March 24, 2017

Comments for 2440 Louisiana NE

Response to comments in RED by DPS.

(A3) SITE PLAN
1" = 20'-0"

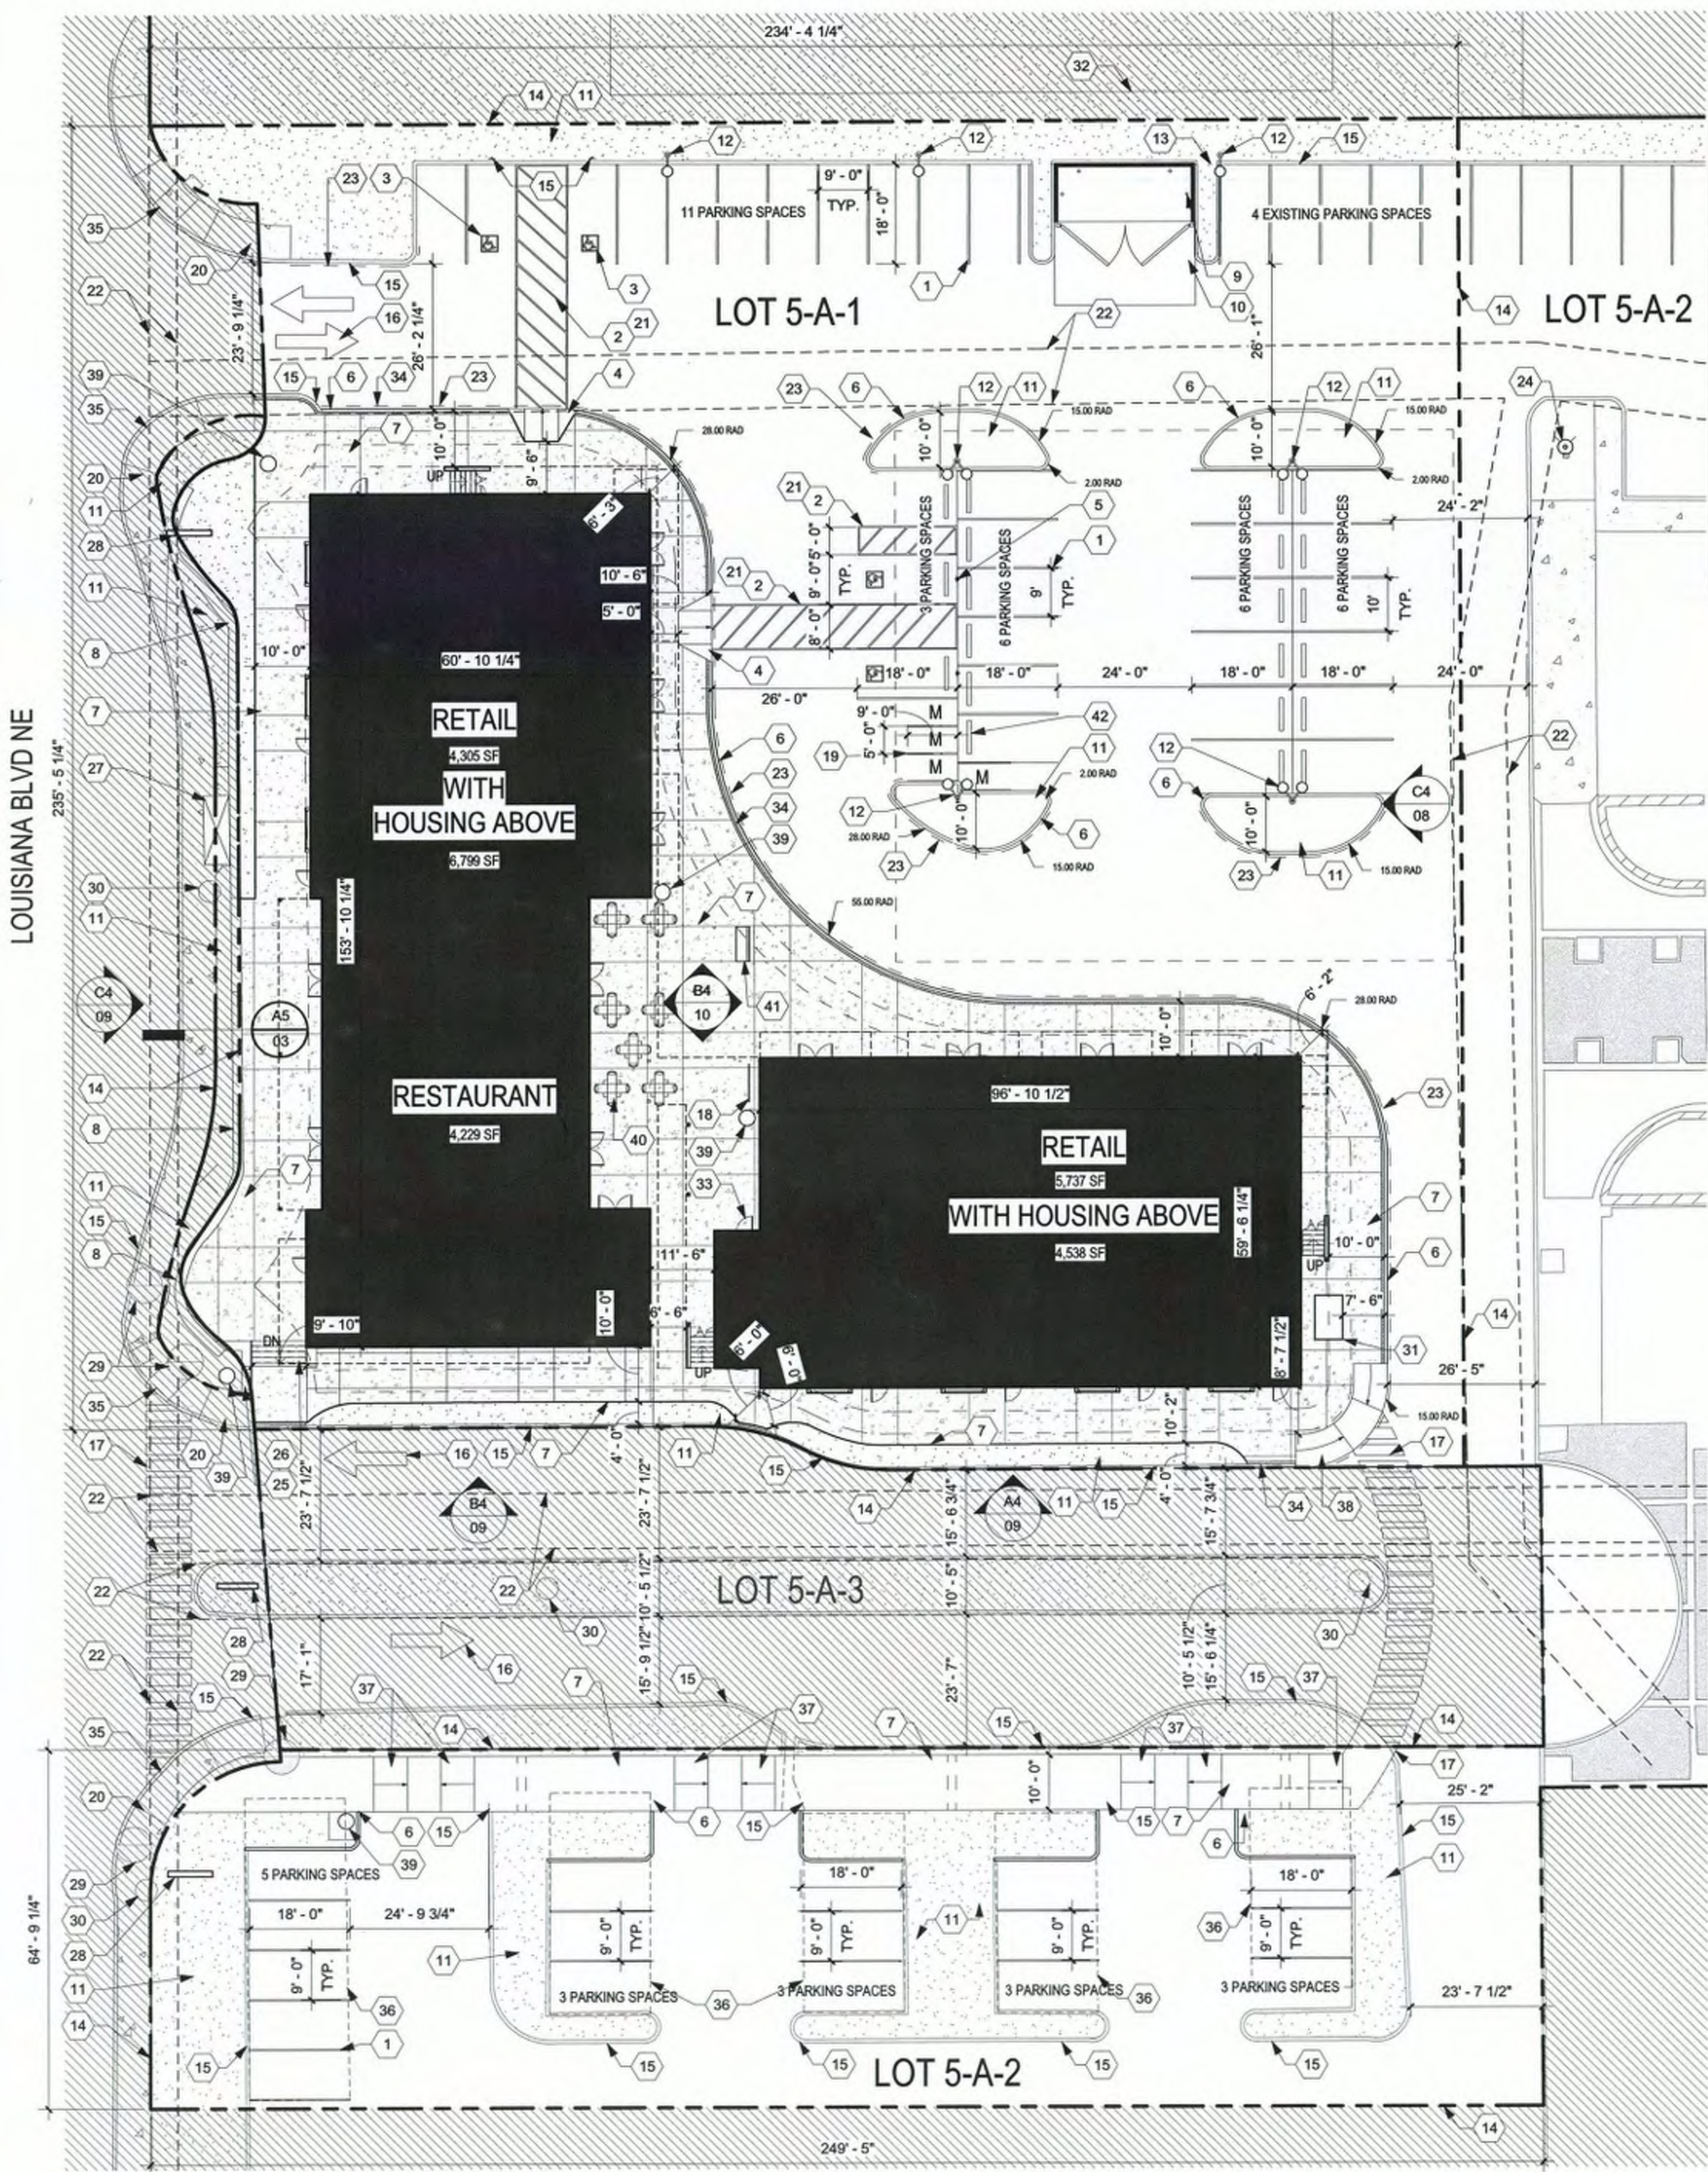
2. The ADA parking space highlighted in the attached scan does not have a safe path to the building. I would suggest moving it and the access aisle to the west so it can share the connection with the other two ADA accessible spaces.

The ADA parking space has been revised to provide a safe path to the building. (RE Sheet 02)

A2 TRASH ENCLOSURE PLAN
1/8" = 1'-0"

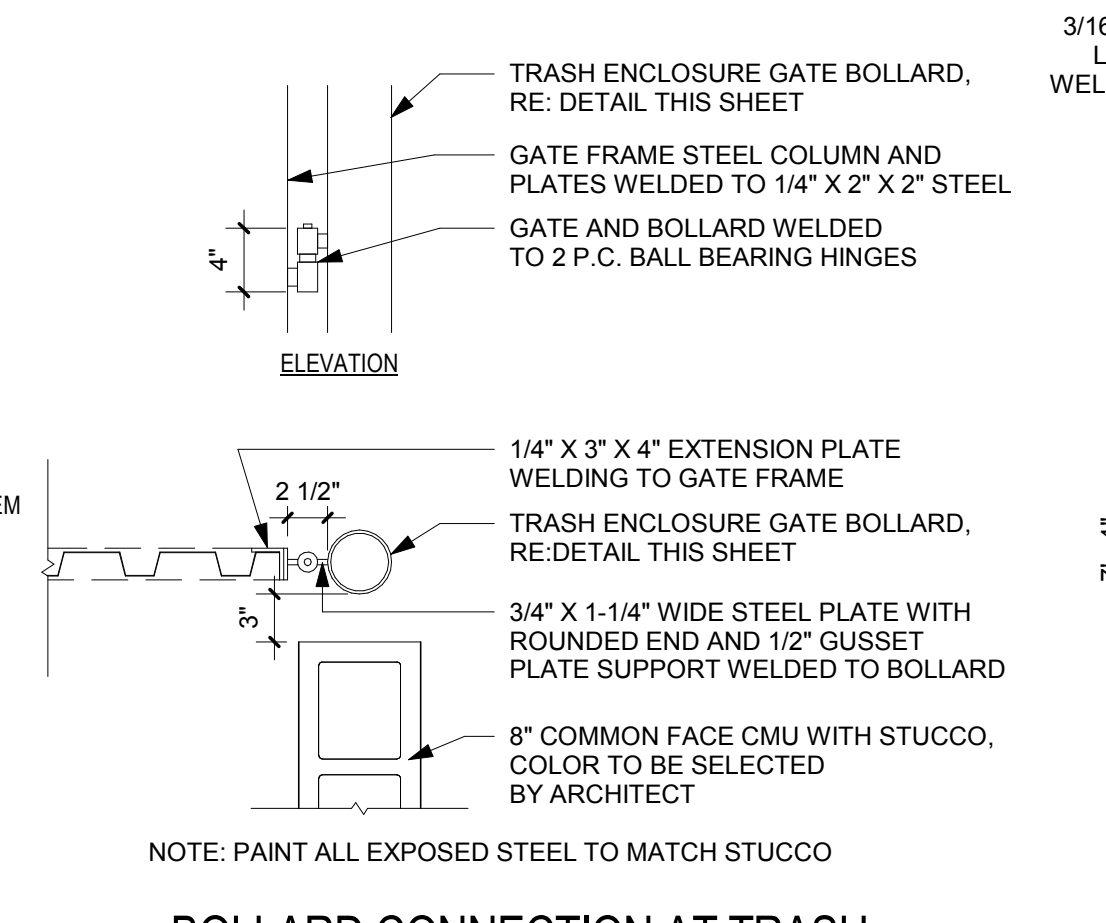
Please center trash enclosure in between parking islands. Currently parking islands are hindering refuse vehicle access to enclosure. Vehicle should have a straight access in and out.

Trash Enclosure has been centered to provide straight in and out access.

A1 PLANTING PLAN
1" = 20'-0"
0 20' 40'

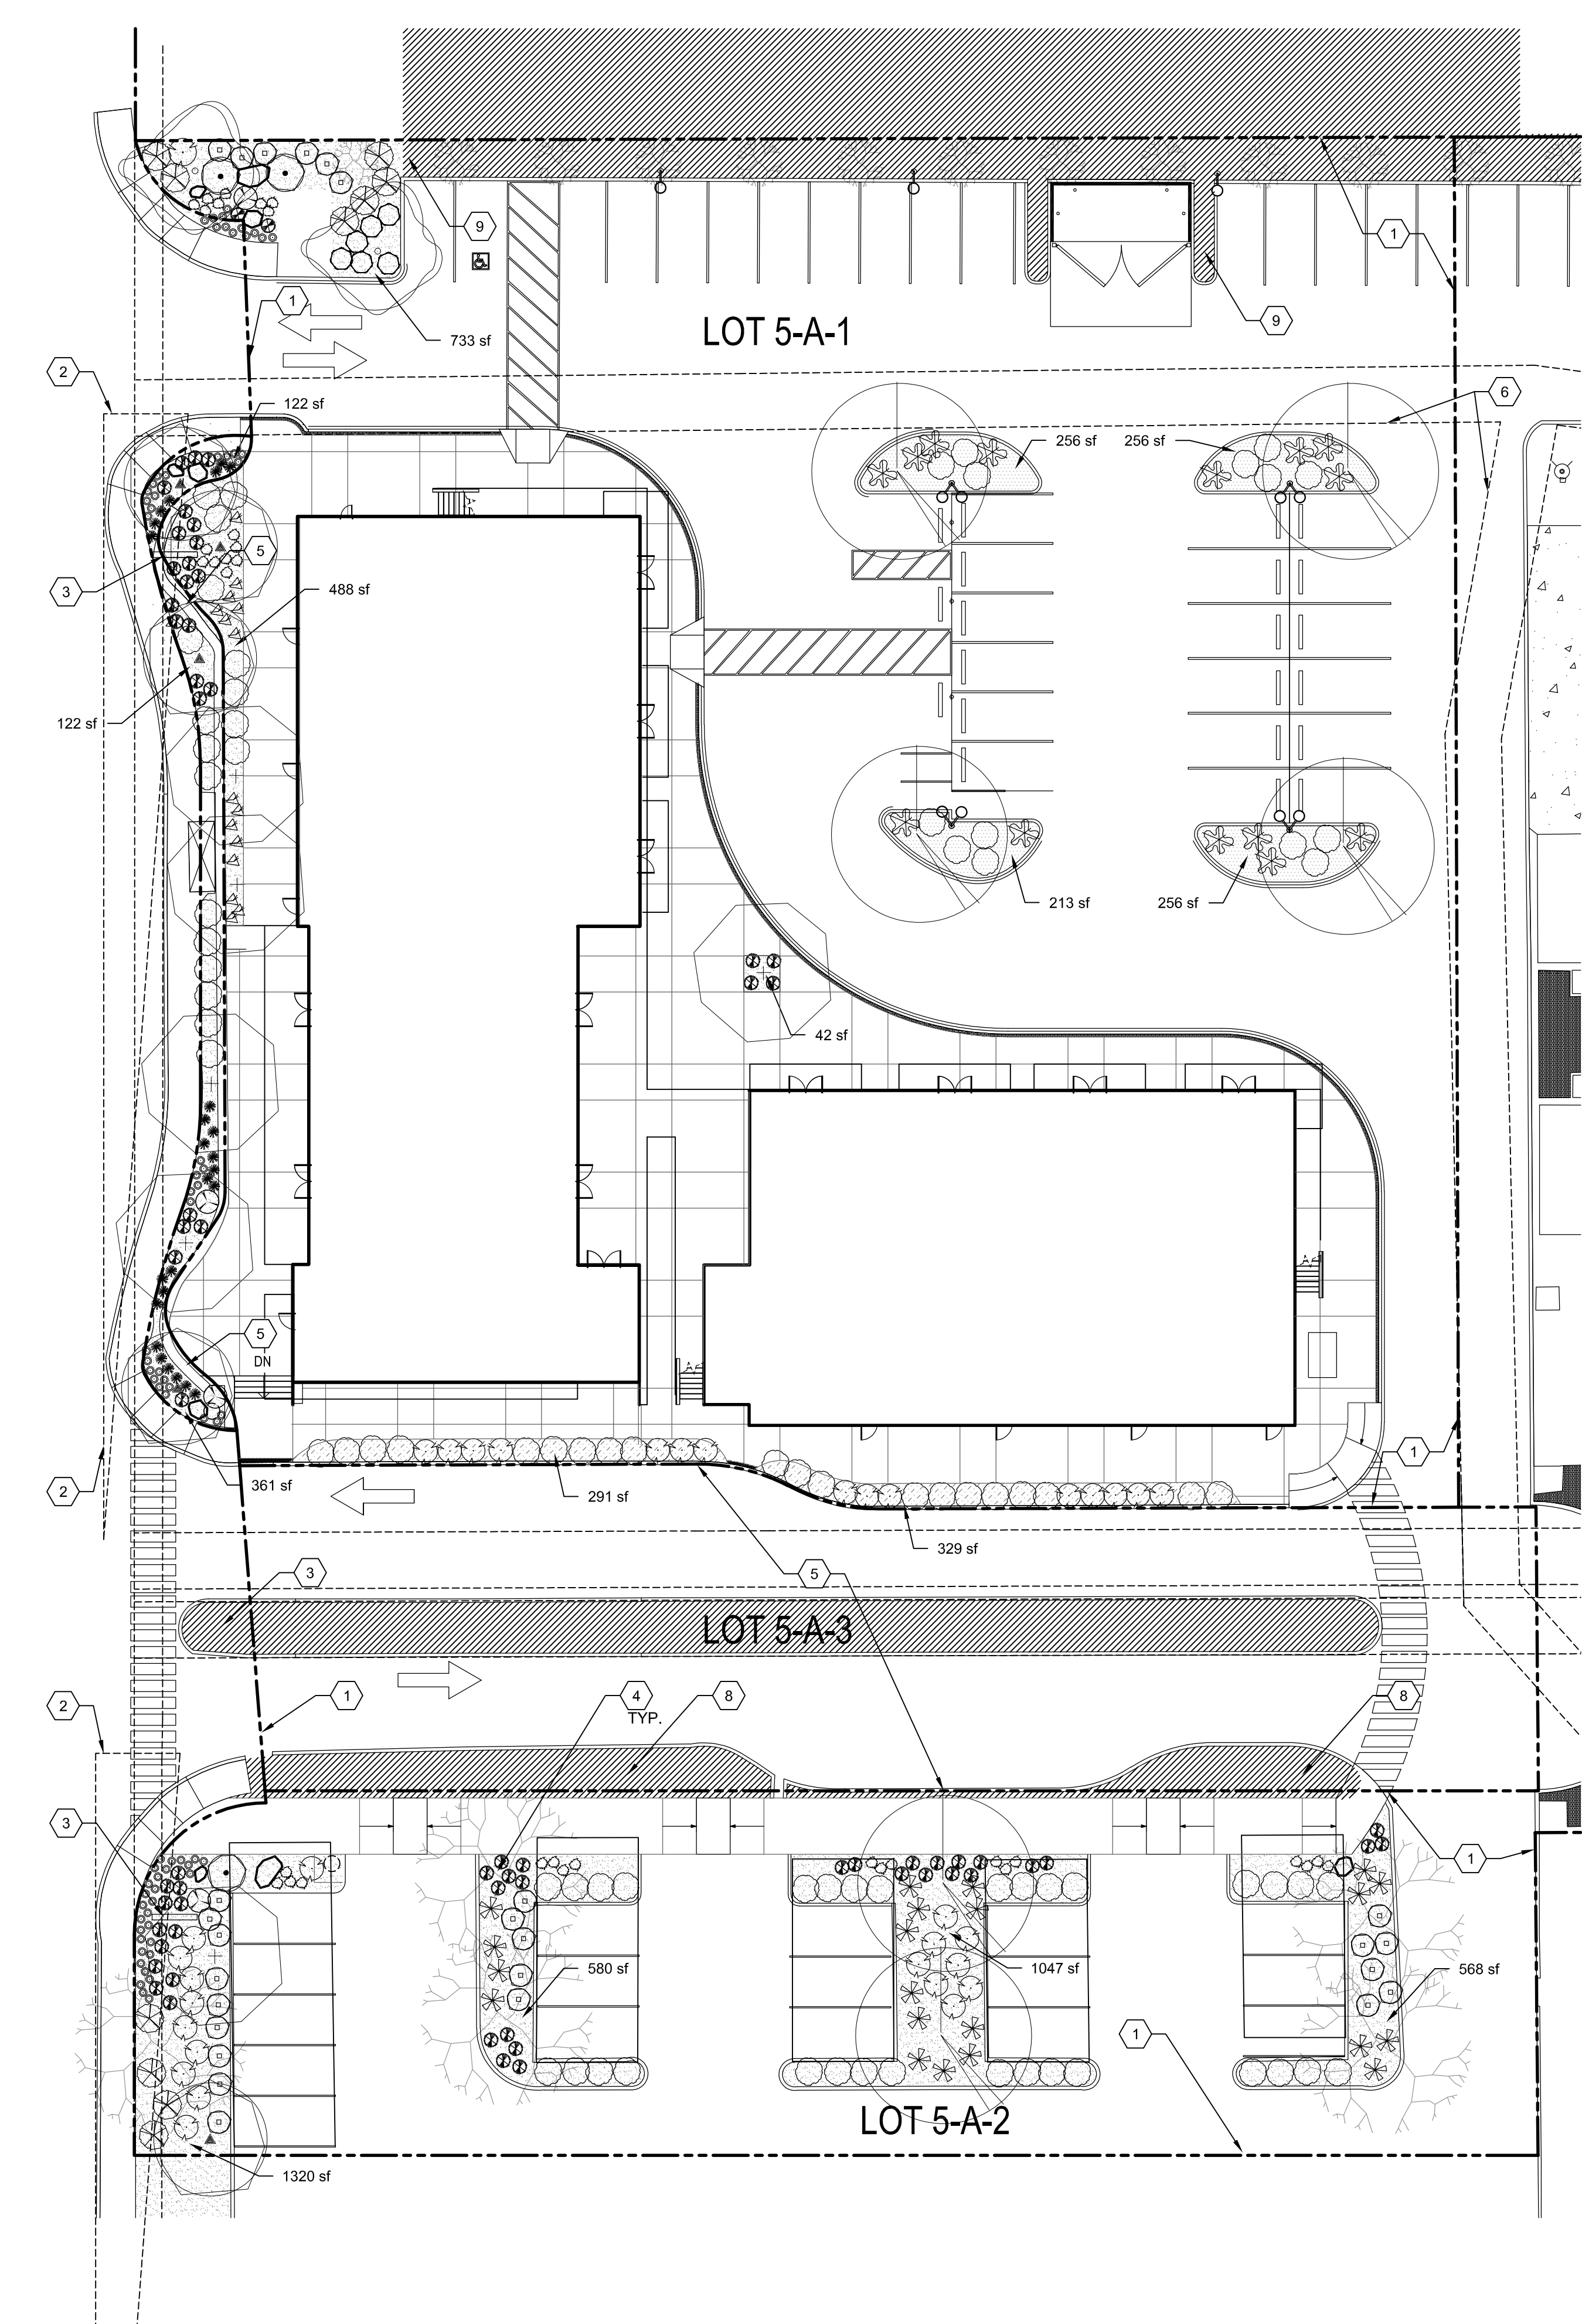
Remove trees from parking islands tree canopies hinder refuse truck turning radius. Possible Center one tree per island so canopy does not encroach into turning radius.

Shade trees have been removed to accommodate refuse truck. Trees are not able to be centered, as pole lighting is centered in islands. (RE: Sheet 06)
